Rezoning Transportation Analysis

Petition Number: 2022-118

Date	Description
12-29-22	First Review (IW)

8835 HARRISBURG RD CHARLOTTE NC 28215
REZONING

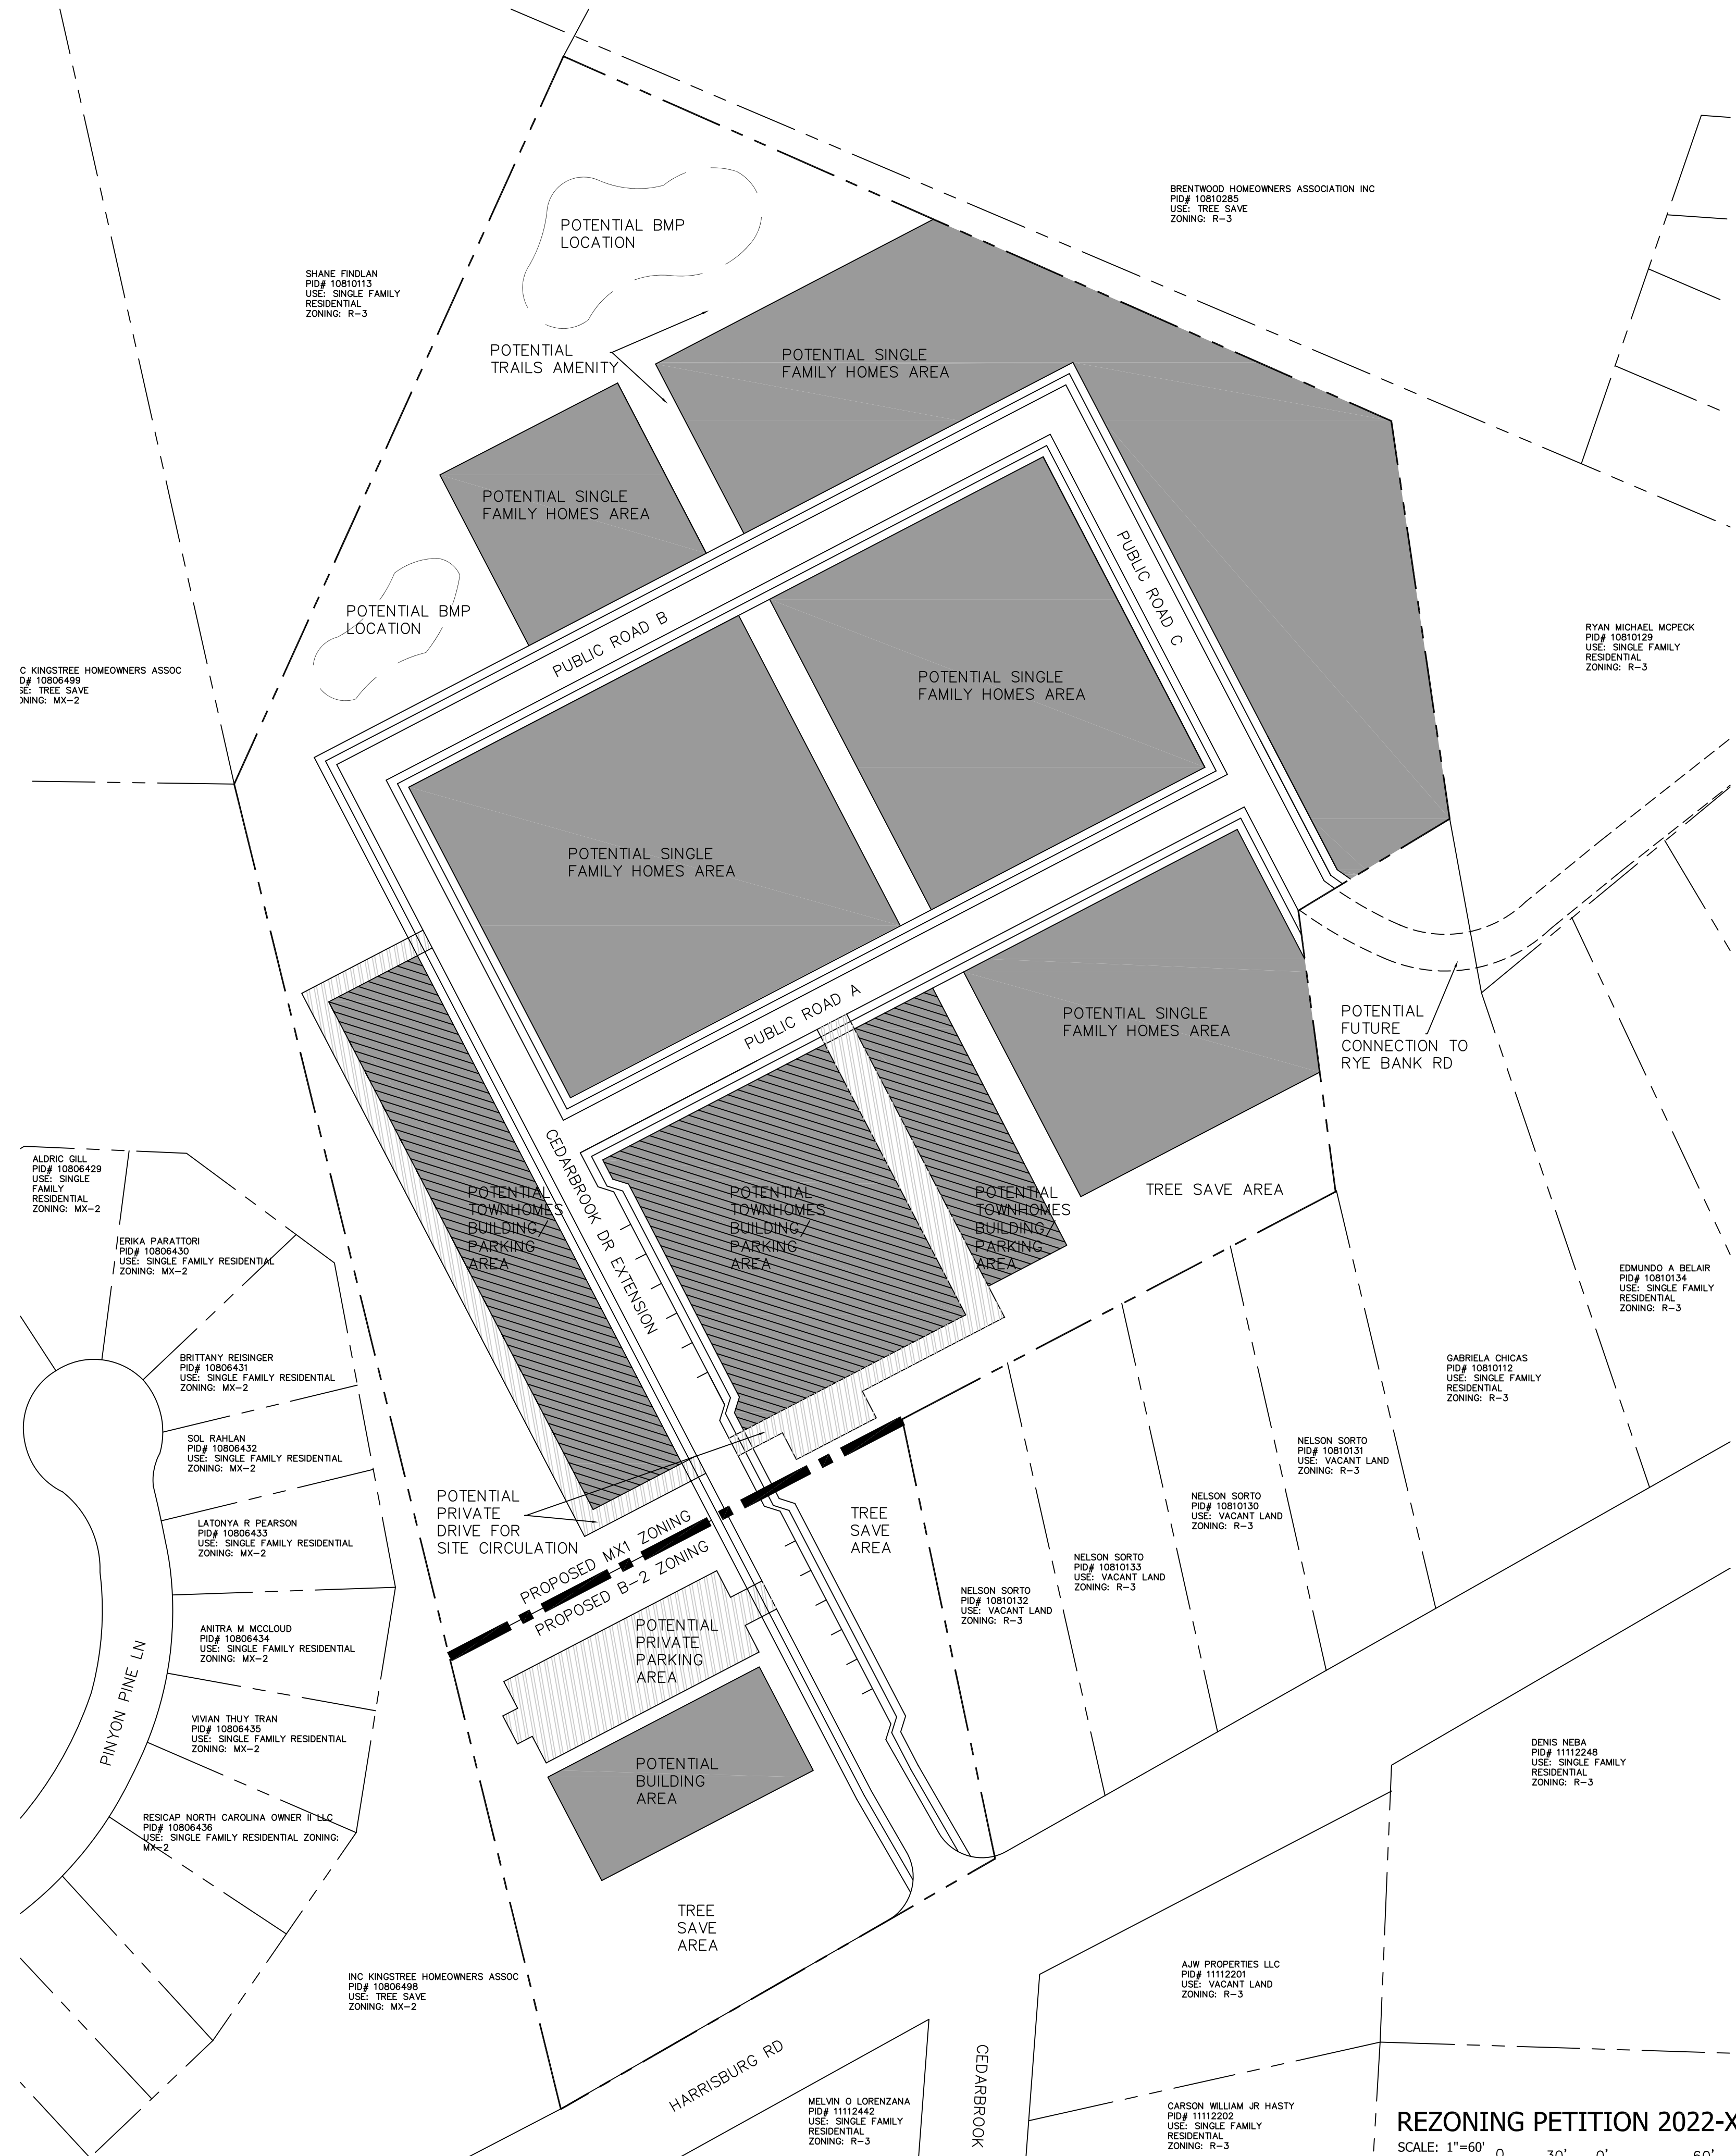
- a. **Harrisburg Road:** Location of curb and gutter to be moved to 30 feet from roadway centerline to accommodate the Charlotte Streets Map with a roadway typical section of CLDSM 11.09 Major Thoroughfare.

Label and dimension the curb and gutter from the centerline for each road on the site plan.

- 3. Revise site plan and conditional note(s) to commit to dedicate 52 feet of right-of-way from the road centerline. The site plan shall label and dimension the right-of-way from the road centerline.
- 4. Per Chapter 20 revise site plan and conditional note(s) to commit to construct an 8-foot planting strip, and 6-foot sidewalk on all internal public roads or if the proposed dwelling units exceeds 12 per acre after verifying density, revise site plan and conditional note(s) to commit to construct an 8-foot planting strip, and 8-foot sidewalk along all internal public Roads. The wider sidewalk also meets the Charlotte WALKS Policy.

The site plan shall label and dimension both items from the back of curb and gutter or edge of pavement.

- 5. Revise site plan and conditional note(s) to commit to construct bicycle facilities by installing a 12' multi-use path to meet the Council-adopted Charlotte BIKES Policy along Harrisburg Road. Multi-use paths maintained by the City shall meet ADA/PROWAG requirements.
- 6. Add a conditional note specifying "A Right-of-Way Encroachment Agreement is required for the installation of any non-standard item(s) (irrigation systems, decorative concrete pavement, brick pavers, etc.) within a proposed/existing City-maintained street right-of-way by a private individual, group, business, or homeowner's/business association. An encroachment agreement must be

7. Revise site plan and conditional note(s) to commit to installing a left turn lane for access off of Harrisburg Road per coordination with NCDOT.
8. Revise site plan and conditional note(s) to commit to extending stem length of Cedarbrook Drive Extension to 100 feet, no parking within that stem. Per coordination with NCDOT.
9. Revise site plan and conditional note(s) to commit to acquiring right of way prior to permit approval. Per coordination with NCDOT.
10. CDOT Request: If possible, revise site plan and conditional note(s) to commit to improving Cedarbrook Drive alignment per coordination with NCDOT.

11. Revise design of public roads to remove 90 degree turns.
